**Section 96A of the Town & Country Planning Act 1990 (as amended)
Town and Country Planning (Development Management Procedure) (England) Order 2015 (as amended) - Article 10**

Non-material amendment following grant of BE/135/18/PL for Unit 5 plans, elevations and sections updated to include: Canopies over drive-thru windows added, drive-thru windows revised, curtain walling mullions/transoms re-positioned, roof colour corrected, cantilevered beams added to roof overhang

Land At Salt Box West Of Shripney Road Bognor Regis PO22 9NW

DRIVE THRU 2
PROPOSED SECTIONS
1744-DT2-P04-B

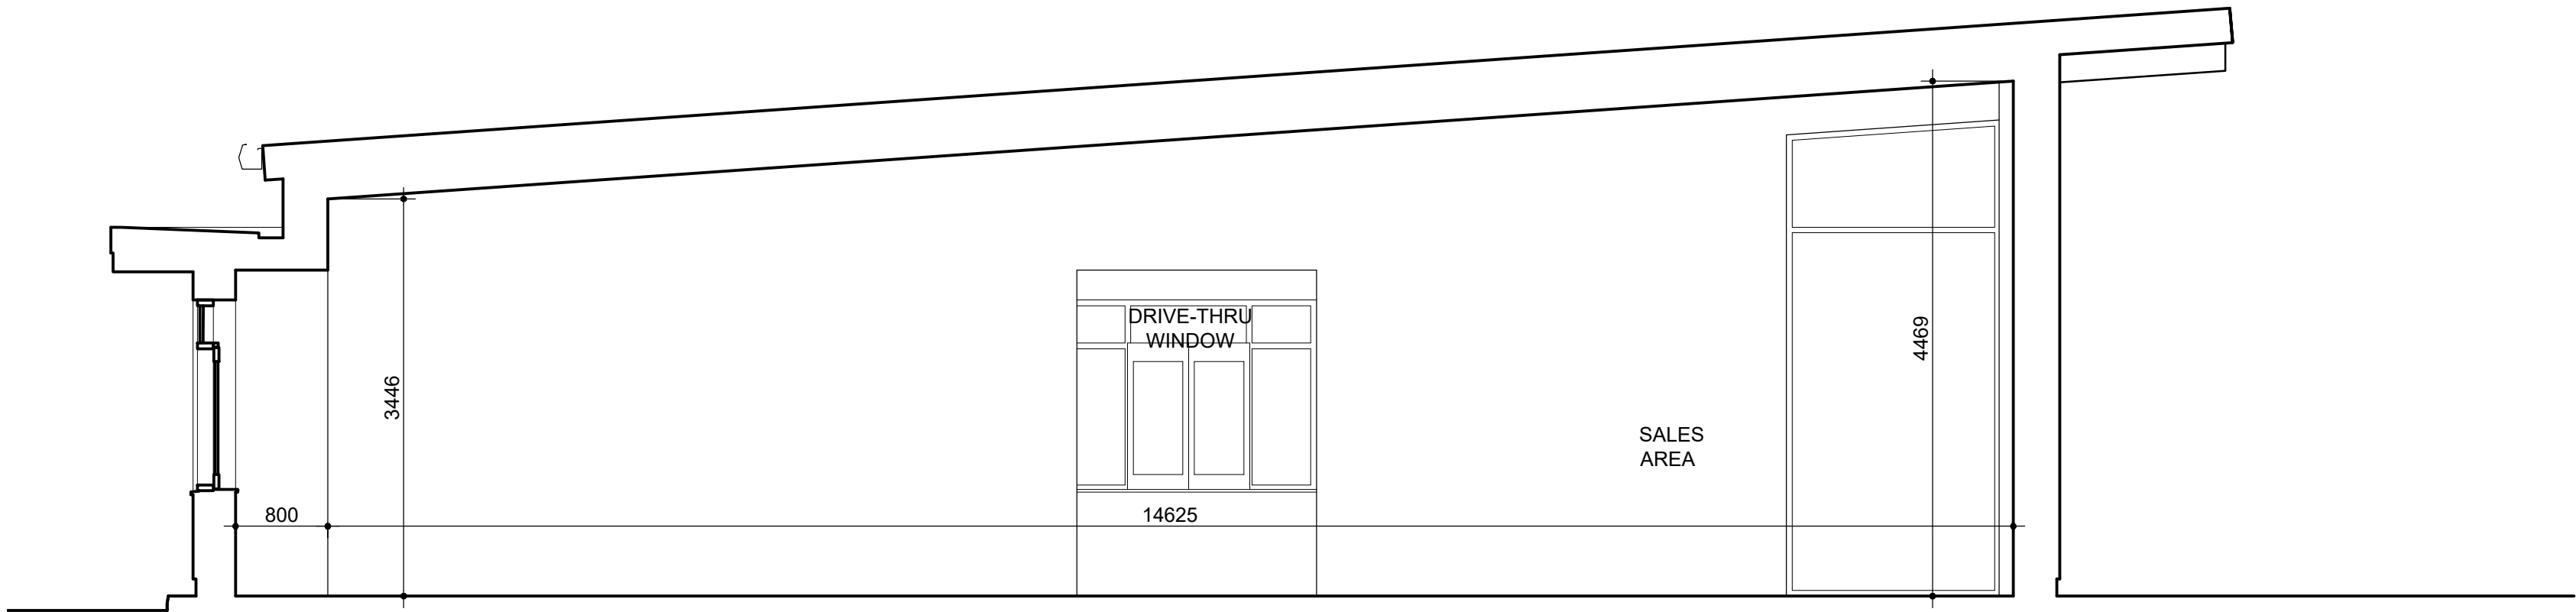
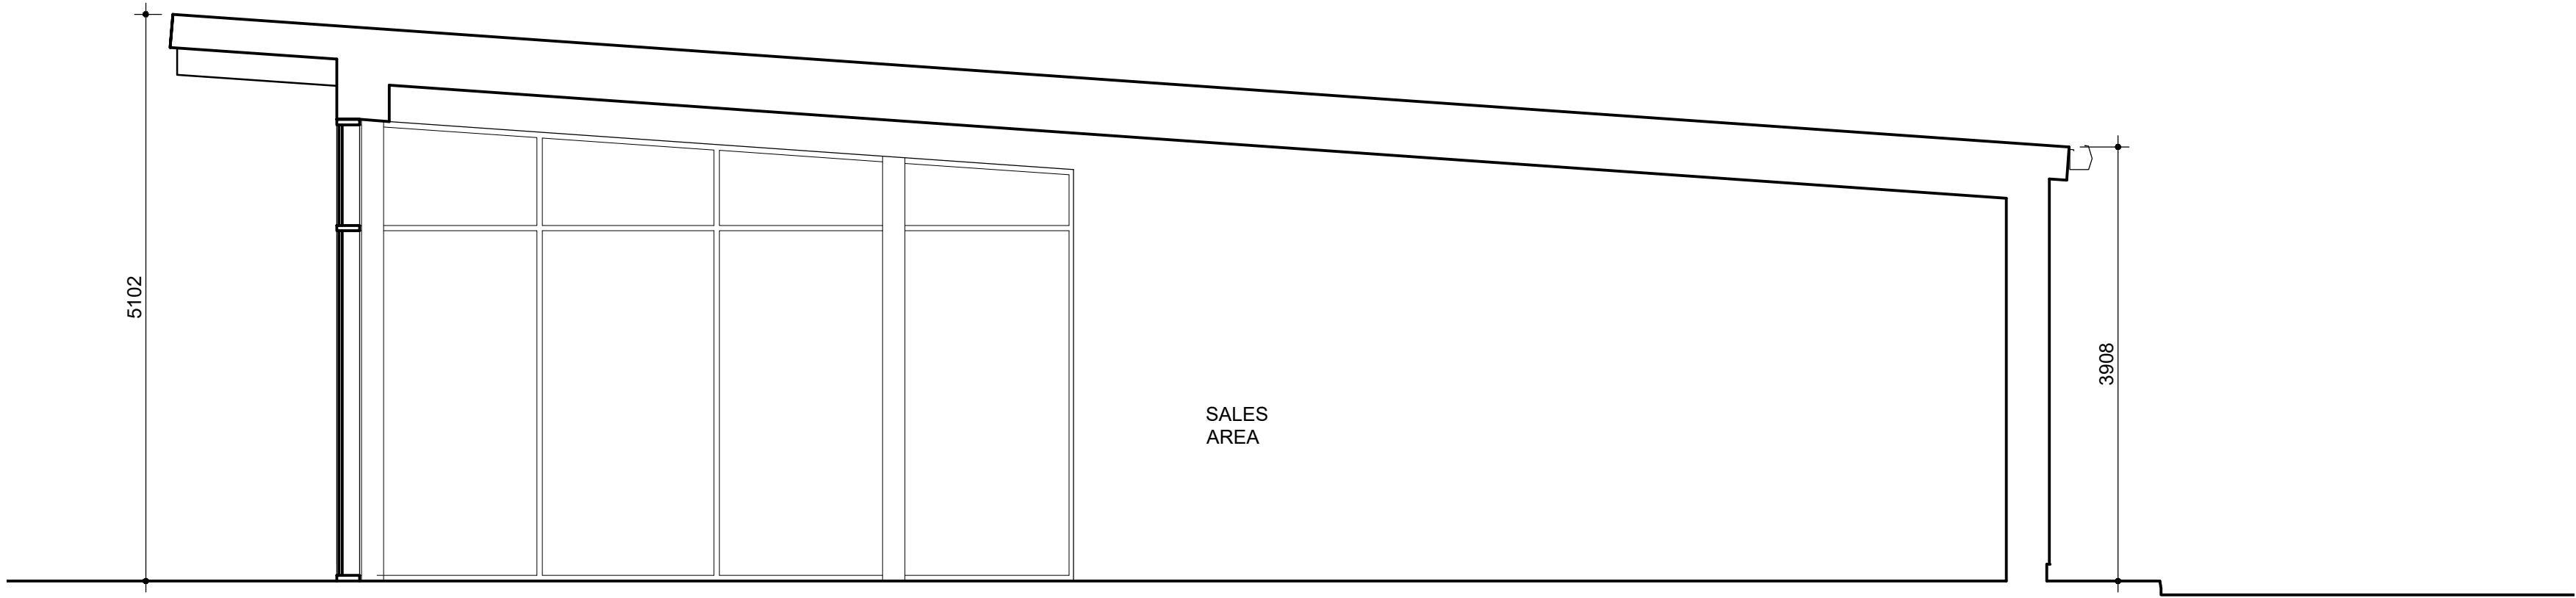
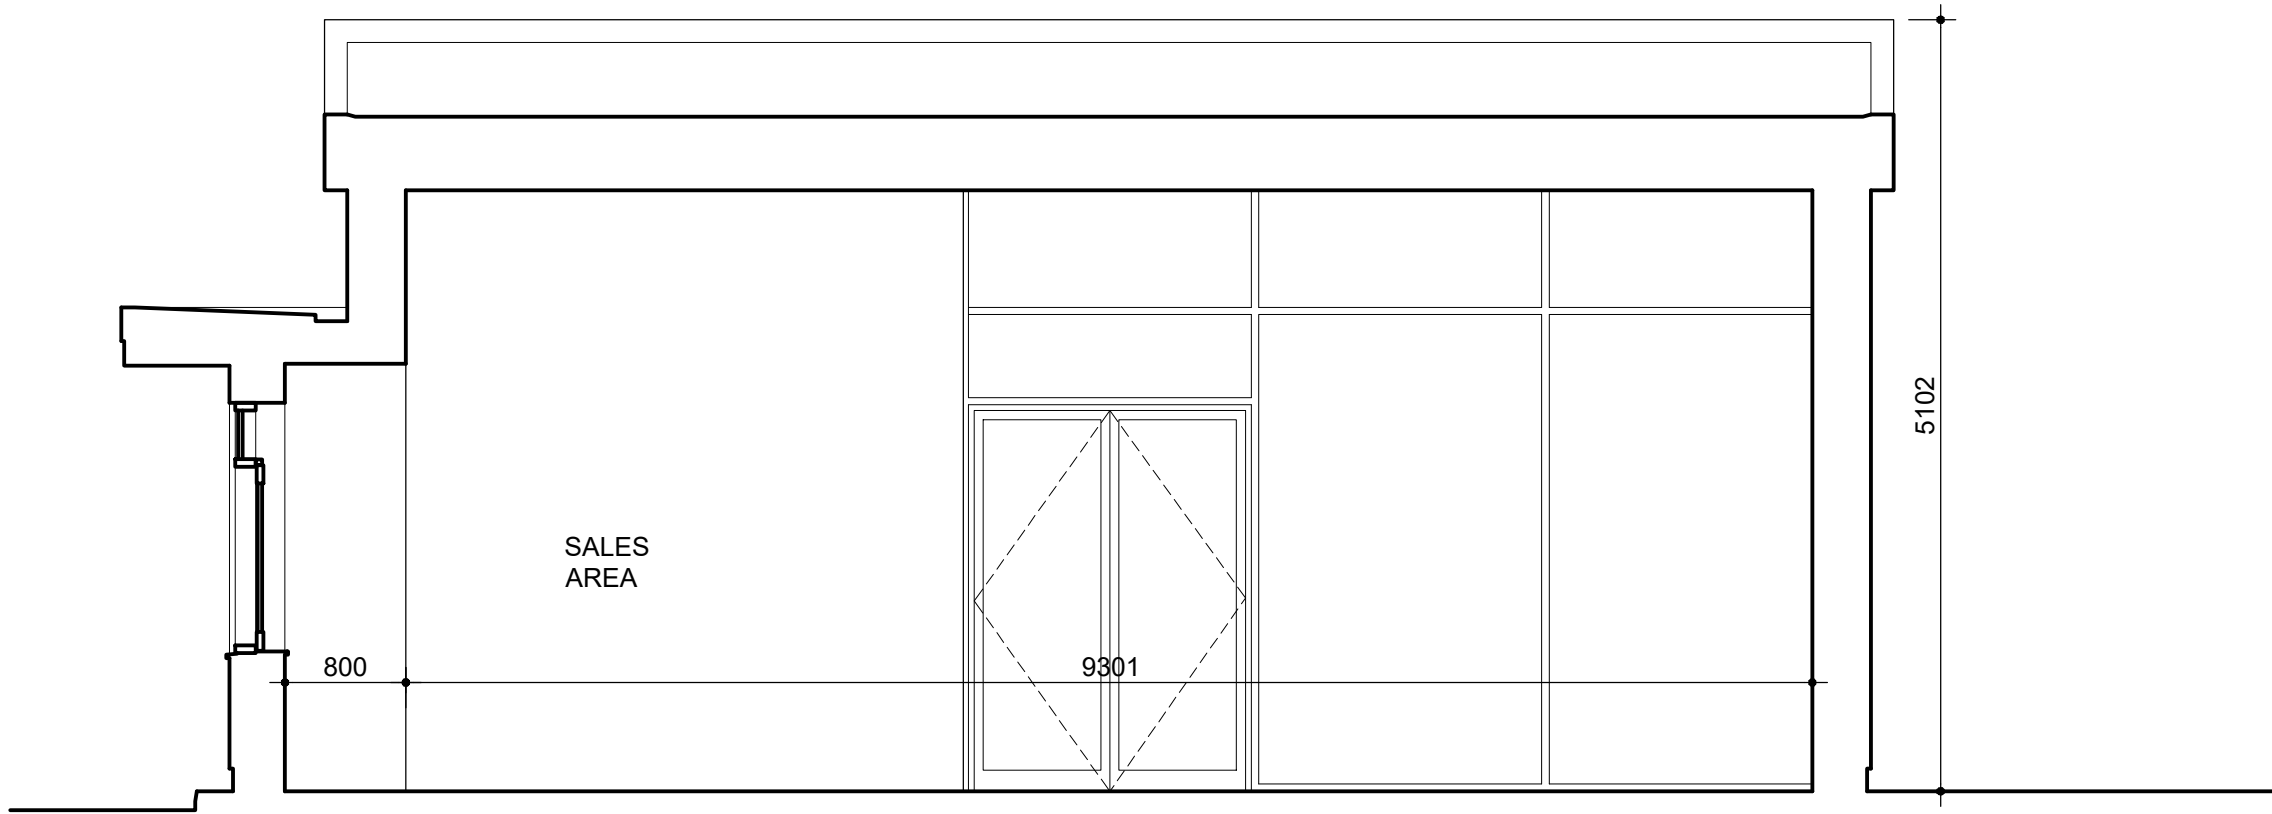
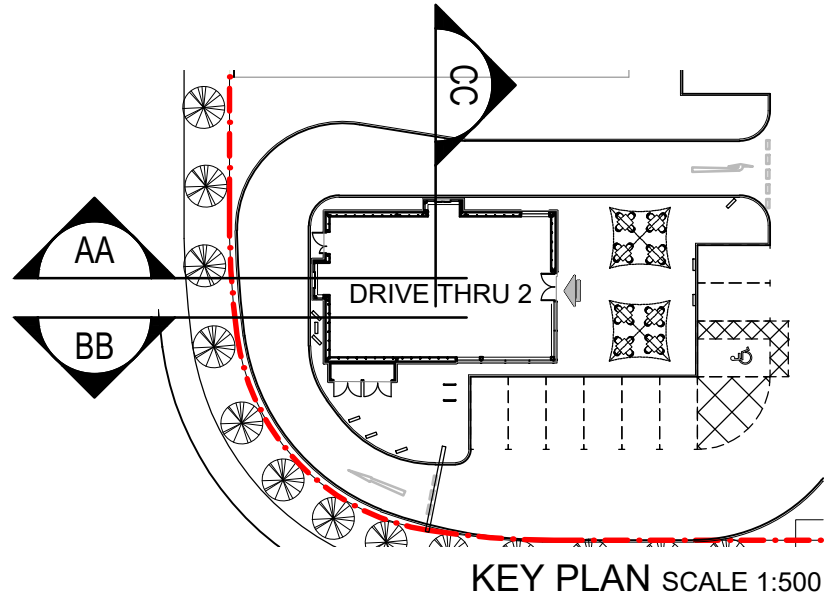
The reason that this proposal has been accepted as a Non-Material Amendment is because it regularises a change on site which comprises alterations to the elevations and sections of Unit 5 (i.e. Drive Thru 2) to include canopies over the drive-thru windows, drive-thru windows revised, curtain walling mullions/transoms re-positioned, the roof colour corrected, and cantilevered beams added to the roof overhang, and it can therefore be considered under section 96A of the Town and Country Planning Act 1990.

Please note that Drawing No. 1744-DT2-P02 Rev. B - Drive Thru 2 Ground Floor Plan, Drawing No. 1744-DT2-P03 Rev. C - Drive Thru 2 Proposed Elevations and Drawing No. 1744-DT2-P04 Rev. B - Drive Thru 2 Proposed Sections now form part of the approved planning documents and drawings for
